Recommendation Report for Planning Permission for Works or Extension to a Dwelling

REF NO: BR/289/21/HH

LOCATION: 5 Oxford Street
Bognor Regis
PO21 2PG

PROPOSAL: Single storey rear extension.

PROPOSED GROUND FLOOR PLAN

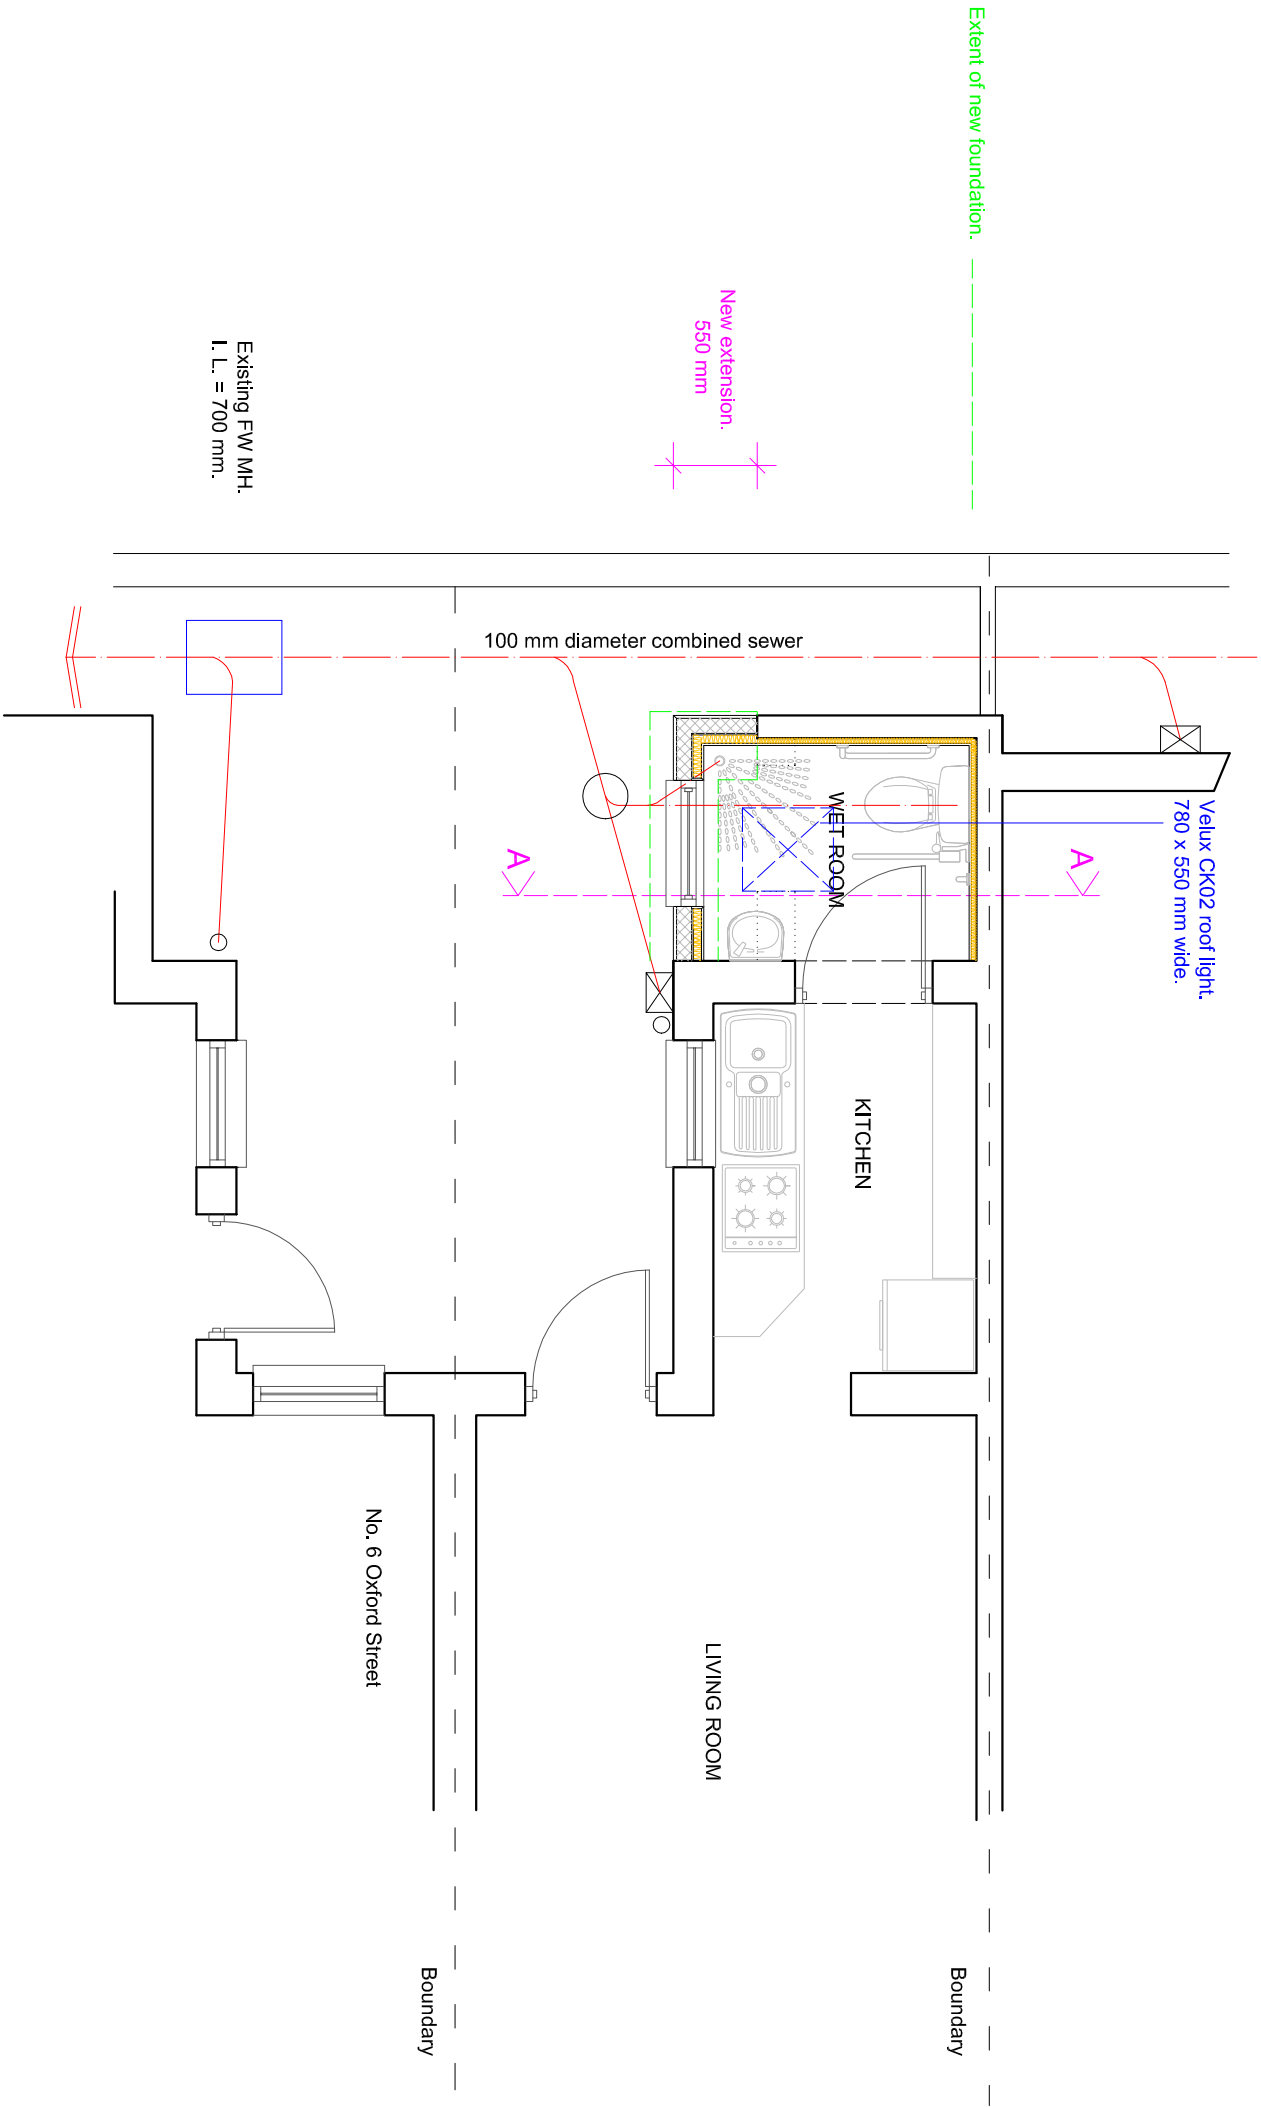
The extension will be 0.54m deep and 1.61m wide, and extend from an existing building to provide a wet room. It will have a pitched roof which will connect to the outbuilding roof, matching the same pitch and design. This will allow for close integration and ensure minimal impact on the visual appearance of the property. Neighbouring properties in the vicinity exhibit similar style buildings, and the proposal will be in keeping with the character of the area. Being to the rear, the proposal will not be visible from the street scene and will have no impact on the composition or appearance of the street.

PROPOSED ELEVATIONS

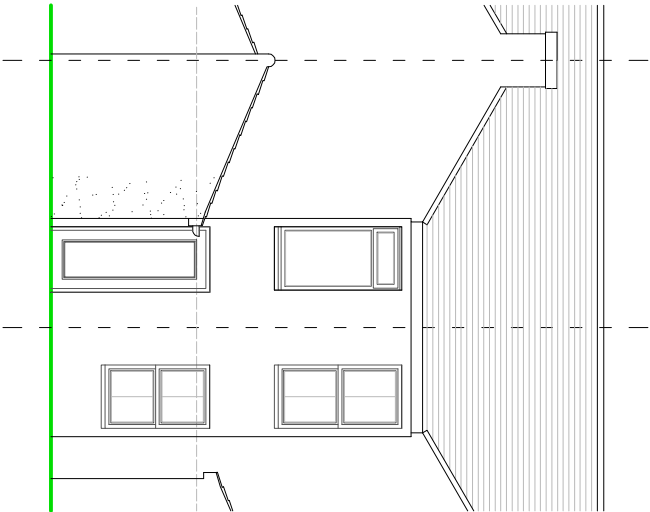
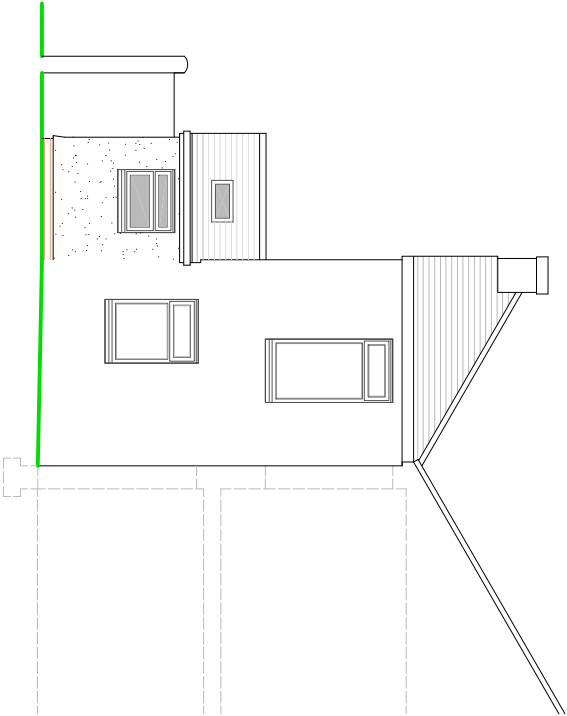
The proposal is single storey, and will have a pitched roof which extends from the existing. This existing roof has a top height of approximately 2.95m, with the proposal measuring 1.98m at the eaves and 2.25m where it meets. There will be a distance of 0.965m retained from the north (rear) boundary, and 1.445m from the west. Given its minimal size and location, the proposal is not considered to result in any overbearing or overshadowing, or harm to neighbouring amenity, and is in accord with D DM4 of the Local Plan.

There will be a window situated to the west elevation, and a velux rooflight on the roof. These features are minimal and well placed, resulting in no overlooking of neighbouring properties. They will cause no harm to neighbouring privacy or amenity and are acceptable.
